## **Parish Council**

**Re: EXQ2 Question 2.5.5 and Applicant's Response**

**Re: Land retention at Church Hanborough and Long Hanborough for "community food growing" by PVDP or associates.**

**11 September 2025**

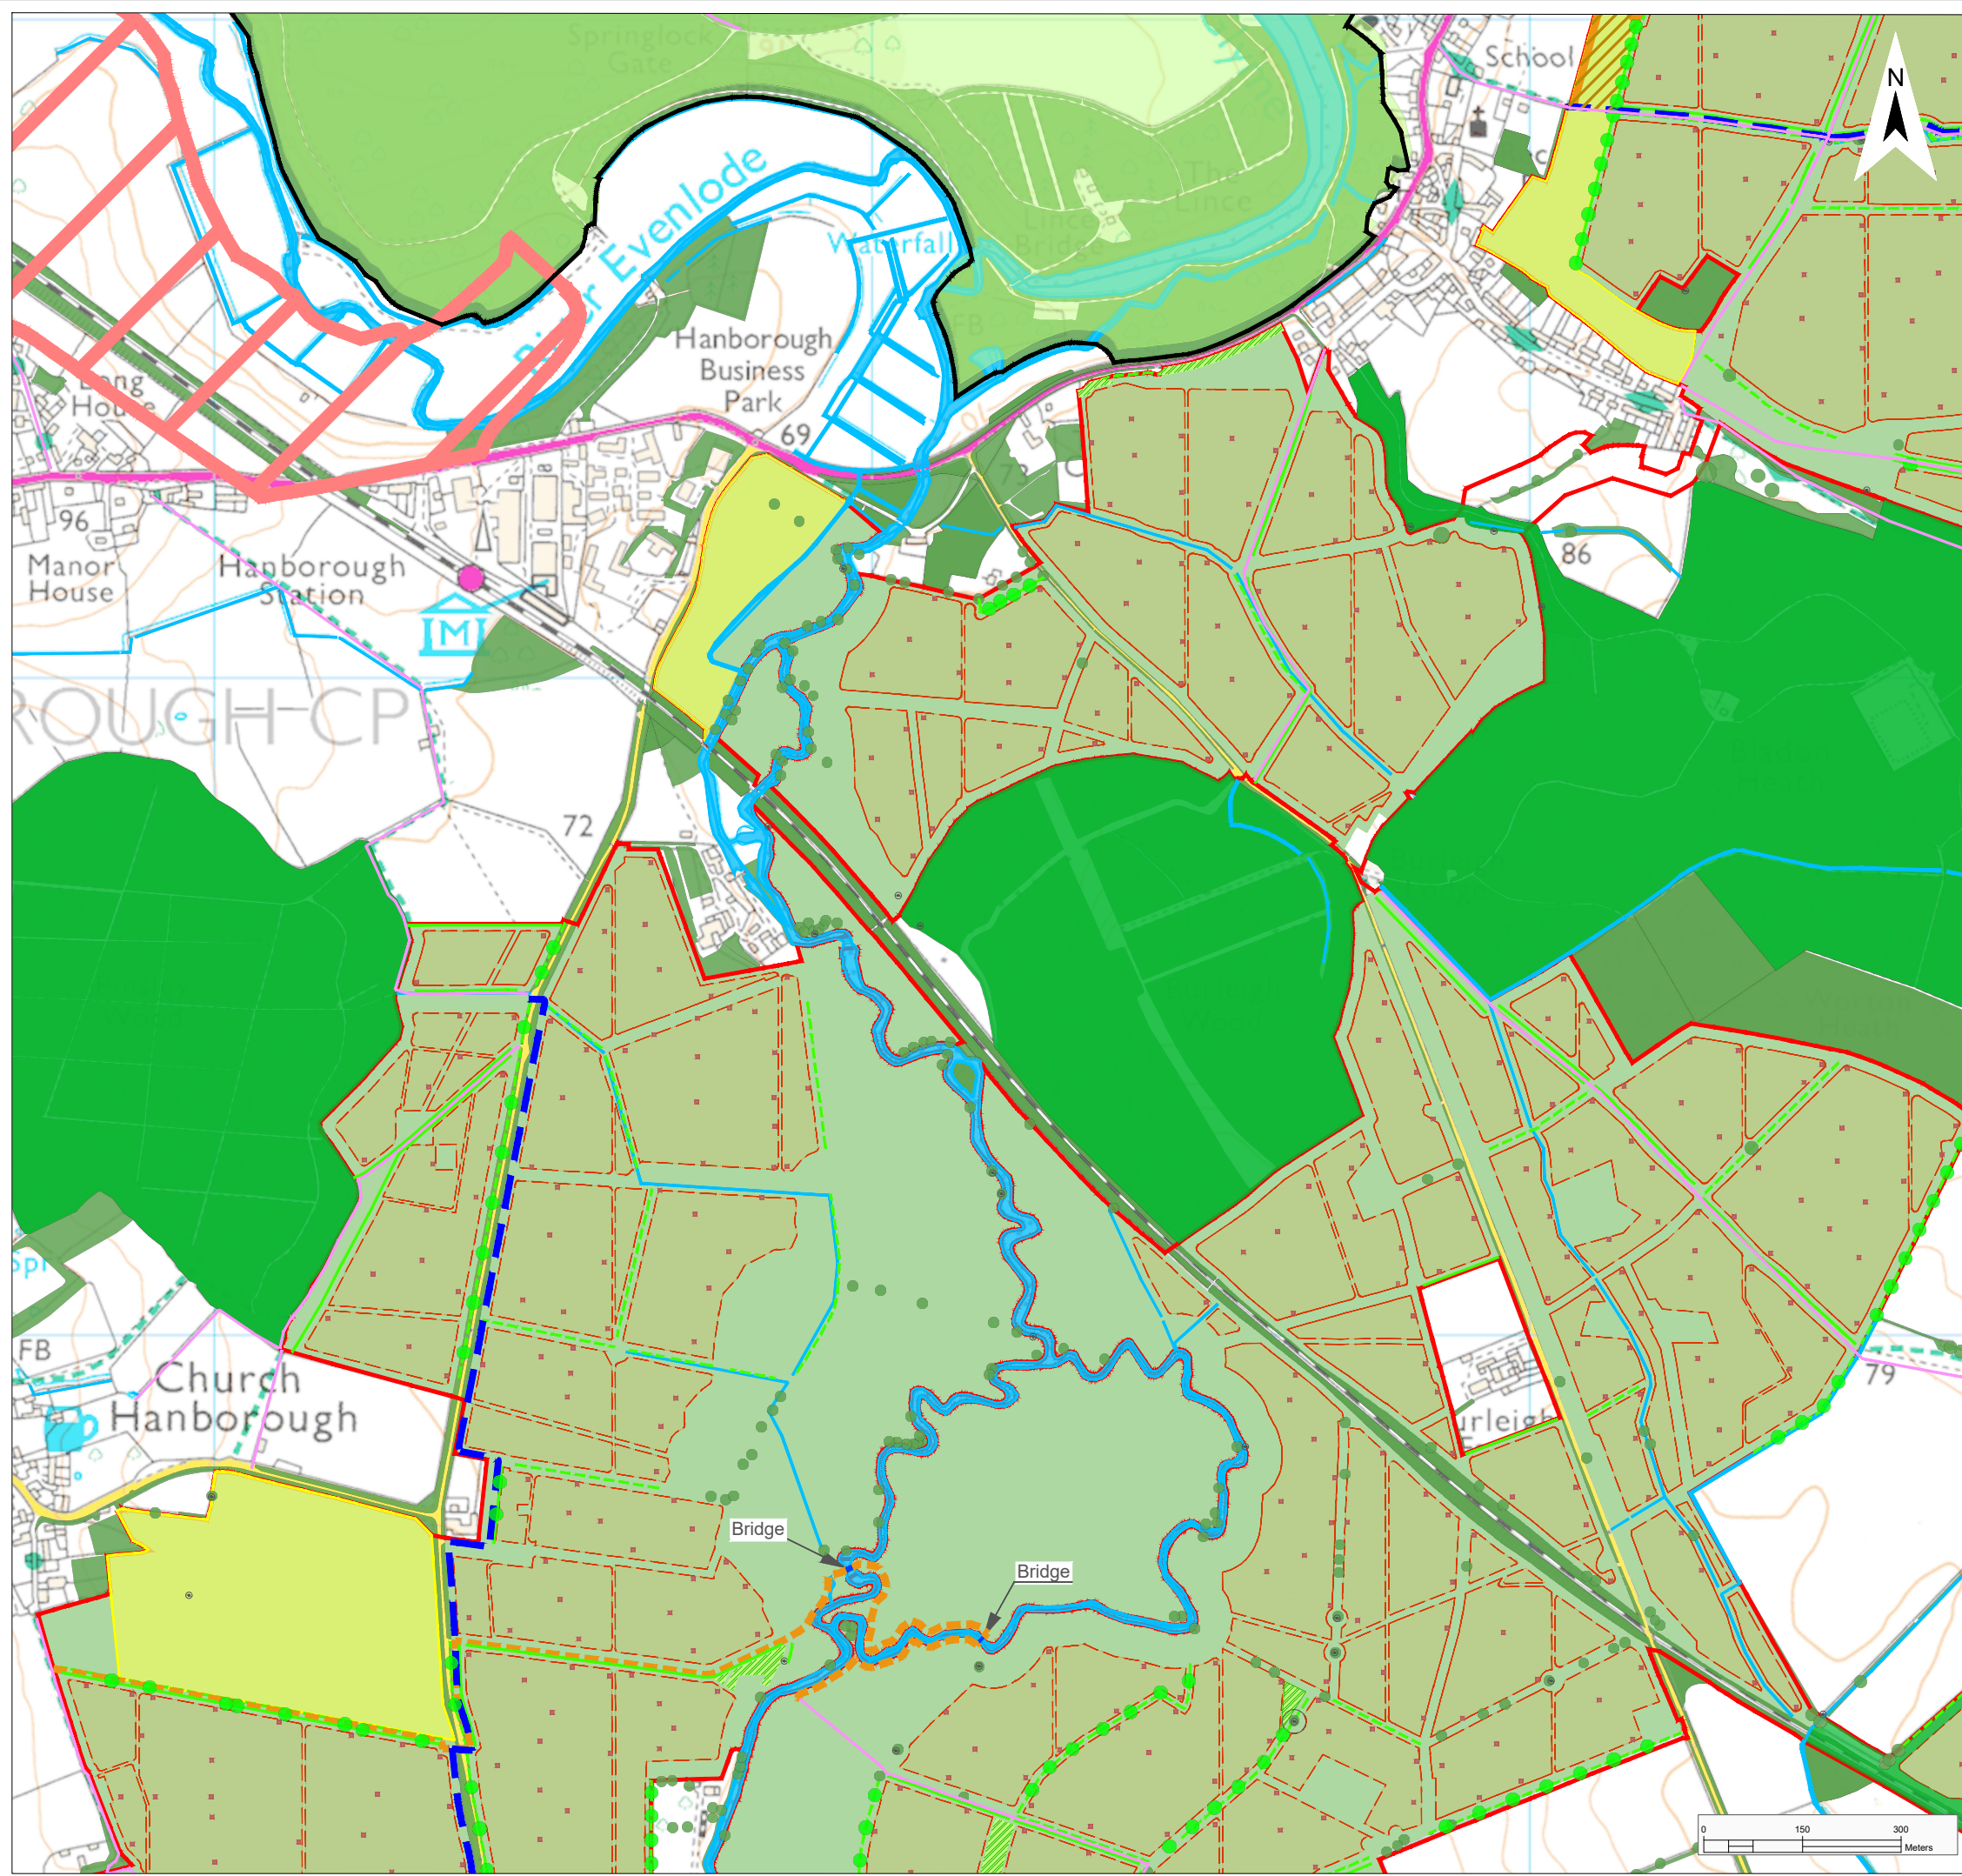
Following extensive discussion, it was agreed that HPC strongly objects, for the reasons cited below, to the land noted in the ExA Question (fields 2.116 and part of 2.115) being used for the purposes proposed by the Applicant.

3. The field is within the Church Hanborough Conservation Area and such use would be detrimental to this status. There would be a huge negative impact on the conservation area of CH and the setting of heritage assets within it (especially St Peter & St Paul Church) which would arise from filling the conservation field with storage sheds, polytunnels, machinery and other paraphernalia associated with food growing - especially on a commercial scale on more than 12 hectares.

5. West Oxfordshire District Council have already raised concerns about the use of the land for such use to the Examiners.
6. PVDP have already been in contact with *OxFarmtoFork initiative* who sell their produce directly to the Oxford Colleges. They evidently consider these growers a better bet because they will operate on a larger scale than Cherwell Collective and Chris Goodall who they also mention.
7. HPC additionally objects to an area of land within the red-line boundary being retained for a proposed similar purpose in Long Hanborough (field 2.34). This is sited on the corner of Lower Rd at the junction with A4095. This field is unsuitable because it floods regularly and has a dangerous access point on Lower Rd.

Hanborough Parish Council objects to the land to the southeast of Church Hanborough, Field 2.116 and the northern section of Field 2.115 (according to the landscape, ecology and amenity plan [AS-022]) being made available for community food growing. This area cannot be used for panels (being part of the conservation area) and is unsuitable for community food growing. There is no reason for it to be included in the DCO application and these fields should be retained for agricultural use and be removed from the red-line boundary. Objection is also made in respect of Field 2.34.
